From: Amanda Scholes on behalf of Planning.Responses
Sent: 22 May 2018 08:42
To: Planning Scanning
Subject: FW: Planning Consultation on: FG/39/18/PL

Comment form Greenspace

Site Address: Worthing Peugeot Littlehampton Road Ferring
BN12 6PB

Description of Works: Demolition of existing property & outbuildings;
erection of new Motor Dealership with
Showroom, Offices & Motor Vehicle Workshop
(including MOT) & new Head Office Facility
adjoining the existing Peugeot building on site
including associated hard & soft landscaping &
associated supporting facilities. This application
is a Departure from the Development Plan.

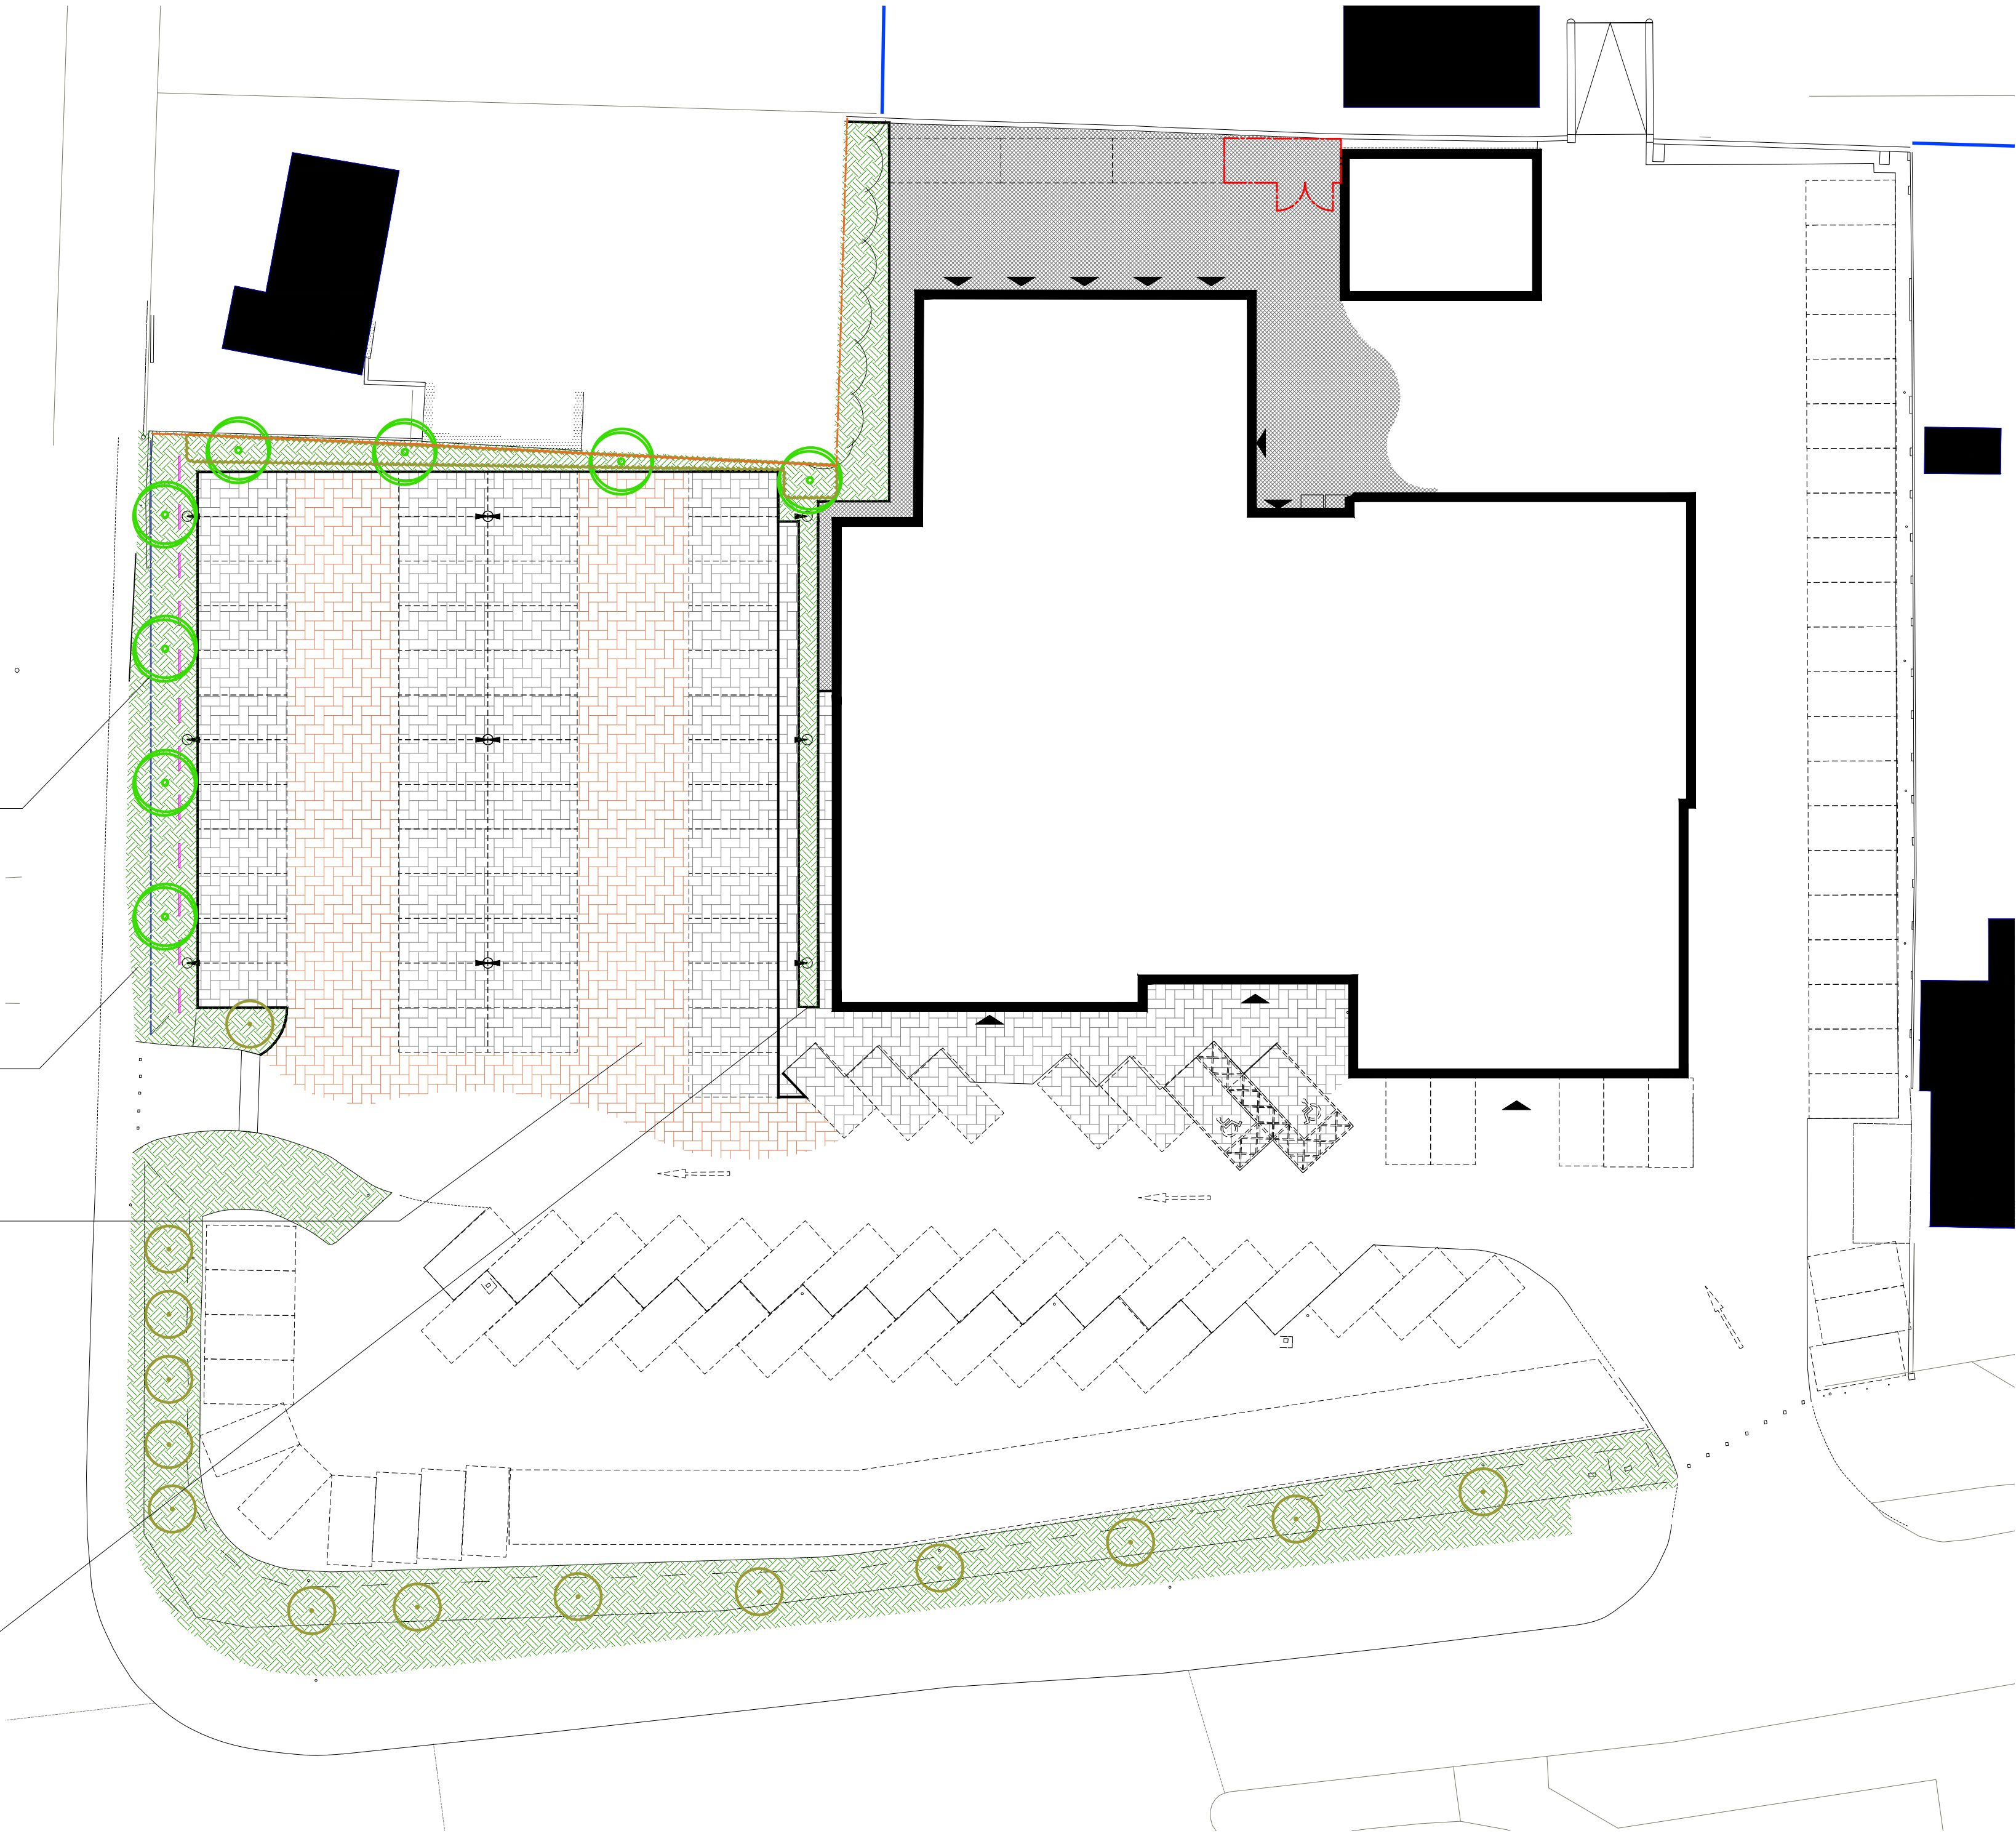
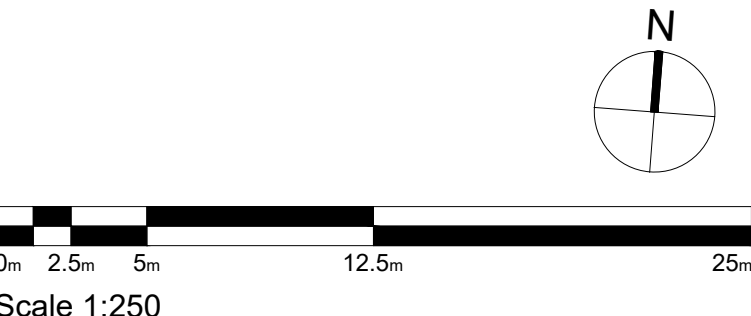
Further to submission of DWG P960 Feb 2018 we advise that the information shown is in indicative form and is lacking in detail. The indicative detail appears to only propose planting to the periphery of the proposals with nothing detailed within the site which may be beneficial. We require that the proposed native hedgerow planting and the low level planted verge detail needs to be detailed in plan form showing species choice, actual proposed planting quantities, planting density and the size of these at time of planting. The indicative trees shown along two of the boundaries which are detailed as native Semi-mature trees, but which are then detailed as 10-12cm girth in size which is a standard tree and not a semi mature. This details needs to be amended so as not to conflict with what is shown and as they are being proposed as screening trees then they need to be at a semi mature size.

We recommend that this information should be submitted for approval or conditioned with any decision.
